Waste Services Consultation Response

Waste Management Officer			Head of Eng. Services	X	Refuse & Recycling Manager	
Description:	3 properties to land off Mill Lane Gisburn BB7 4LN					Ribble Valley Borough Council www.ribblevalley.gov.uk
Application Ref:	3/2017/0750		Case Officer:	SK		
Response Ref:	AH/14		Issue Date:	15/08/17

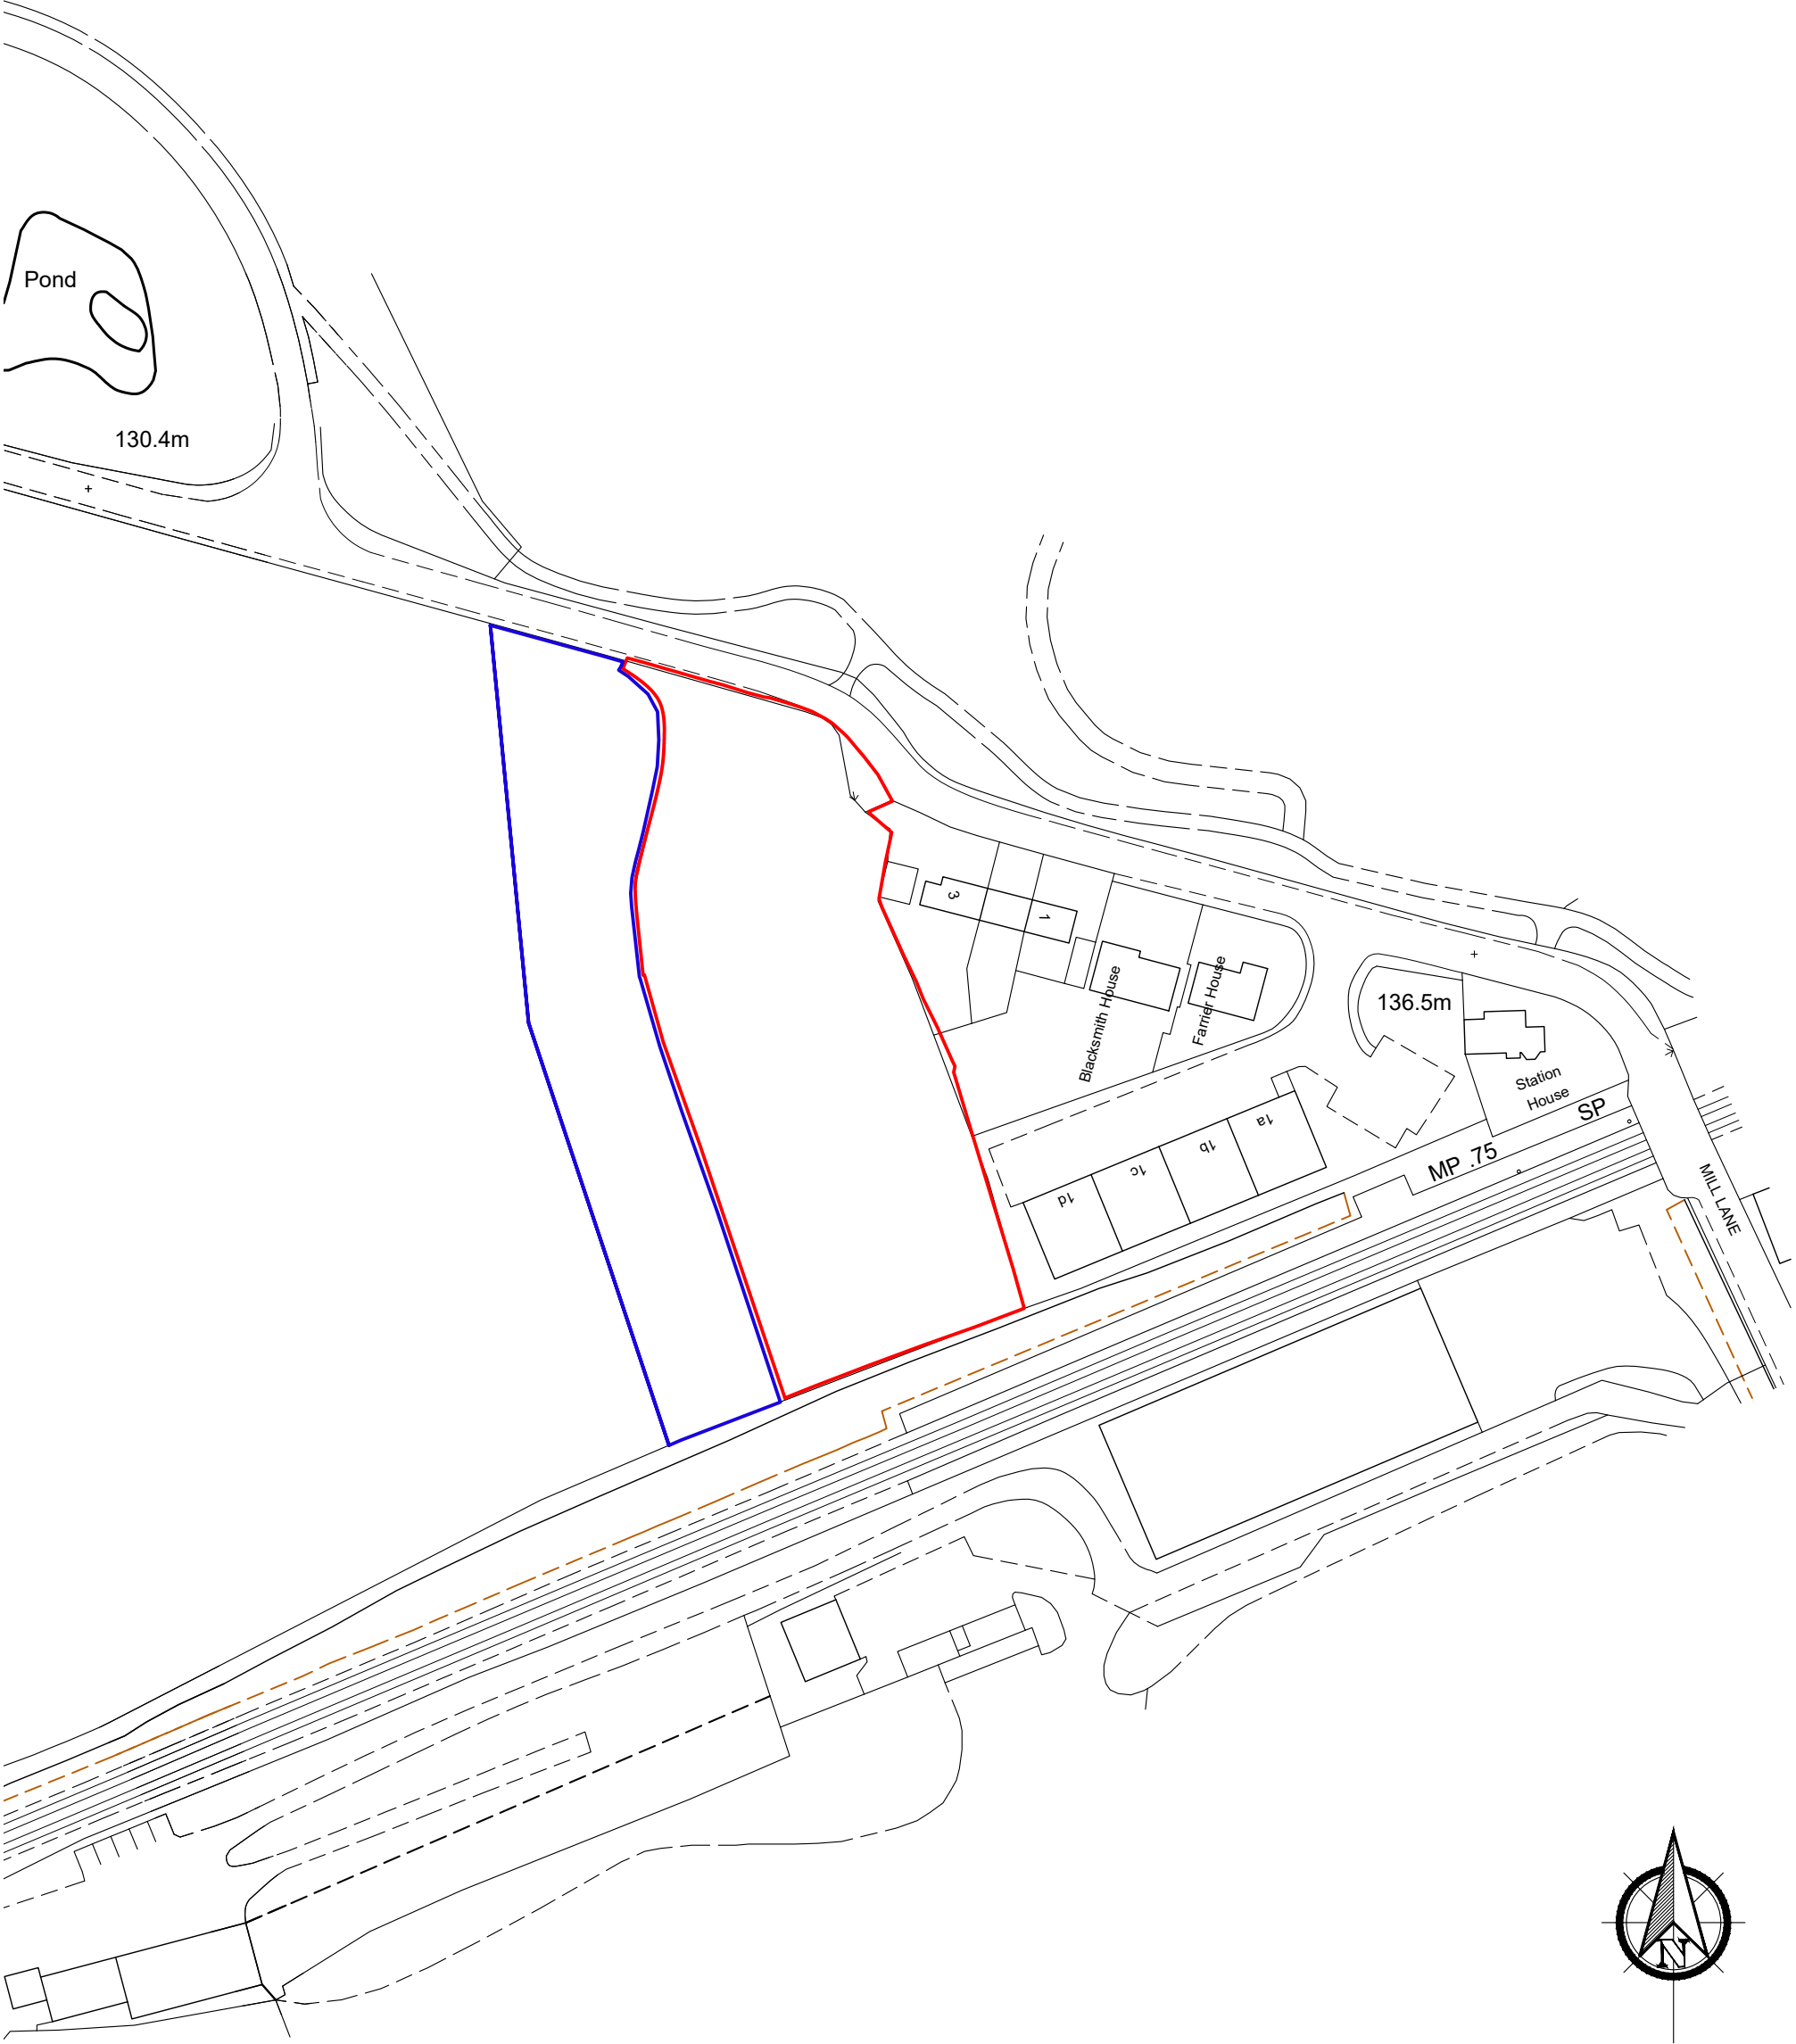
Comments/Observations:						
1.1	Access	Acceptable:	Yes	N/A	No	
1.2 Communal collection from entrance to the site would be expected.						
2.1	Manoeuvrability	Acceptable:	Yes		No	
2.2						
3.1	Collection/Storage Provision:	Acceptable:	Yes		No	x
3.2 Communal collection from entrance to the site would be expected.						
4.1	Additional Observations					
4.2						
5.1	Conclusions/Suggested Conditions:					
5.2	The above observations have been provided on the basis of the level of information submitted and the comments contained within this response represent officer opinion only, at the time of writing, without prejudice.					
5.3	Should you be minded to approve the application, notwithstanding other material considerations, I would suggest that the following conditions be attached should you feel they are relevant and justified:					
Officer :	A. Harper		Date:		18/08/2017
